WATERLOO METRO QUARTER OVER STATION DEVELOPMENT

Response to Submissions
Amending Concept SDDA
10441

WL DEVELOPER PTY LTD

24 March 2021

Analysis of number of hours sunlight to the facade of Building 02 on 21 June, 9am-3pm

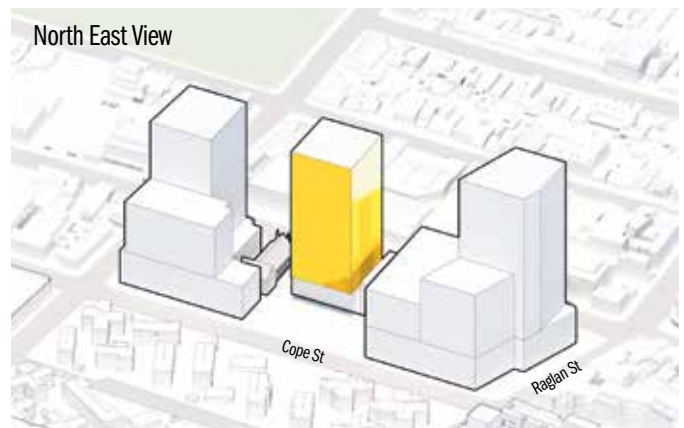
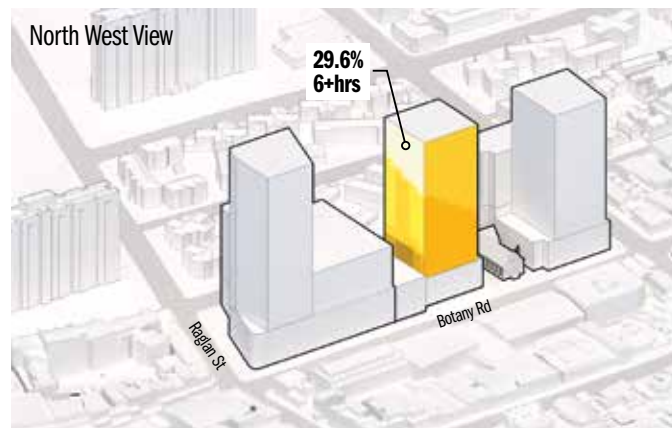
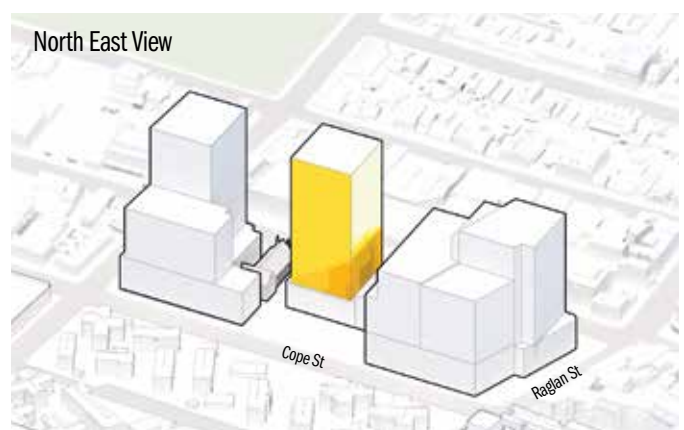
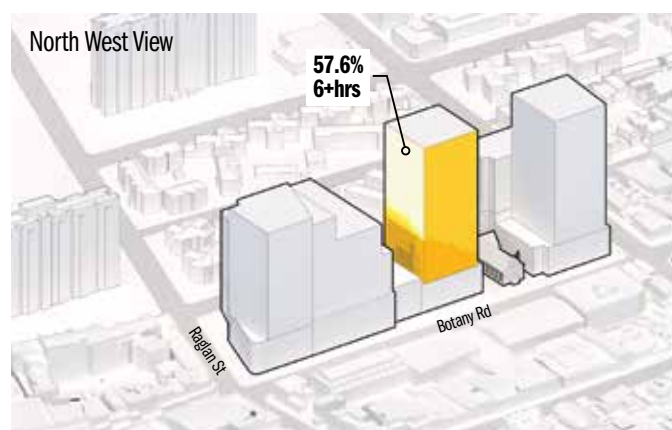
Building 1 – Amending Application	
<p>a. Clause 6.45(2)(d) requires consideration of the Waterloo Metro Design and Amenity Guidelines prior to determining the application.</p>	<p>Noted.</p> <p>Minor amendments are proposed to the WMQ Design and Amenity Guidelines which are provided at Appendix C and addressed in Section 7.1 (as applicable to the Northern Precinct SSD DA).</p>
<p>b. The analysis provided does not demonstrate that Design Criteria 4 of Design Guideline 3M is met and does not respond to the specificity of the criteria, which requires analysis of both ‘at grade’ areas and living rooms windows (living rooms windows are not addressed).</p> <p>The analysis does not acknowledge that properties to the south of the site are impacted to an extent which exceeds the criteria.</p> <p>The Guideline also does not distinguish residential properties by whether they are within a Heritage Conservation Area.</p> <p>The overshadowing analysis indicates a very minor reduction only in overshadowing to Alexandria Park</p>	<p>This amending concept DA seeks to modify:</p> <ul style="list-style-type: none"> ▪ The envelope of Building 1 to enable a midrise envelope that supports the proposed commercial uses in line with the strategic purpose of the Camperdown-Ultimo place strategy and City of Sydney Local Strategic Planning Statement. ▪ The envelope of Building 1 to reduce the maximum permitted tower height commensurate with a reallocation of floorspace from residential to commercial uses.

Comment	Response
<p>between 9am and 10am. The application therefore does not achieve the improvements anticipated in the Guidelines to improve solar access to Alexandria Park through detailed design by reducing the northern tower only, which is not responsible for the non-compliant overshadowing of Alexandria Park.</p> <p>A better urban design strategy would be to reduce the height of that part of the envelope which caused the noncompliant overshadowing.</p>	<ul style="list-style-type: none"> ▪ The envelope of Building 2 to adjust the podium and tower relationship facing Cope Street Plaza to the East. <p>As a result, the analysis of the solar impact for the amended envelope was focused to those areas where the impact previously assessed under SSD-9393 has changed.</p> <p>A Supplementary Solar Impact Assessment has been prepared within the supplementary Architectural Design Report, included at Appendix A. As shown in the report, figures 2.1.1-2.1.7 demonstrate that overall, potential overshadowing to surrounding residential dwellings has been reduced throughout the day as a direct result of the amendments to the concept approval.</p> <p>This changed impact does not remove the requirement for subsequent detailed DAs within the amended envelope to ensure compliance with the provisions of 3A and 3M of the design quality guidelines. This impact will be the subject of detailed reporting prepared by RWDI in support of the detailed SSD DAs. It is noted that the resultant impact of the detailed design of the Northern Precinct by way of SSD 10440 has further reduced this impact.</p> <p>No changes are proposed to the approved enveloped under SSD 9393 that would affect the previously assessed impact which at the time was deemed appropriate for a complex urban centre.</p> <p>Additional analysis undertaken by Hassell to understand the extent of improvement between SSD-9393 and the specific development proposals for the North, Central and South Precinct Buildings has demonstrated that previous expectations of compliance under the approved SSD 9393 were inaccurate with the improved overshadowing provided under SSD-10439 (Central Precinct) and SSD-10437 (Southern Precinct) by the proponent to Alexandria Park in the context of a complex urban environment.</p> <p>The analysis provided in Appendix A demonstrates that on the winter solstice, the amended envelope results in a significant decrease in overshadowing of Building 2 by Building 1.</p>
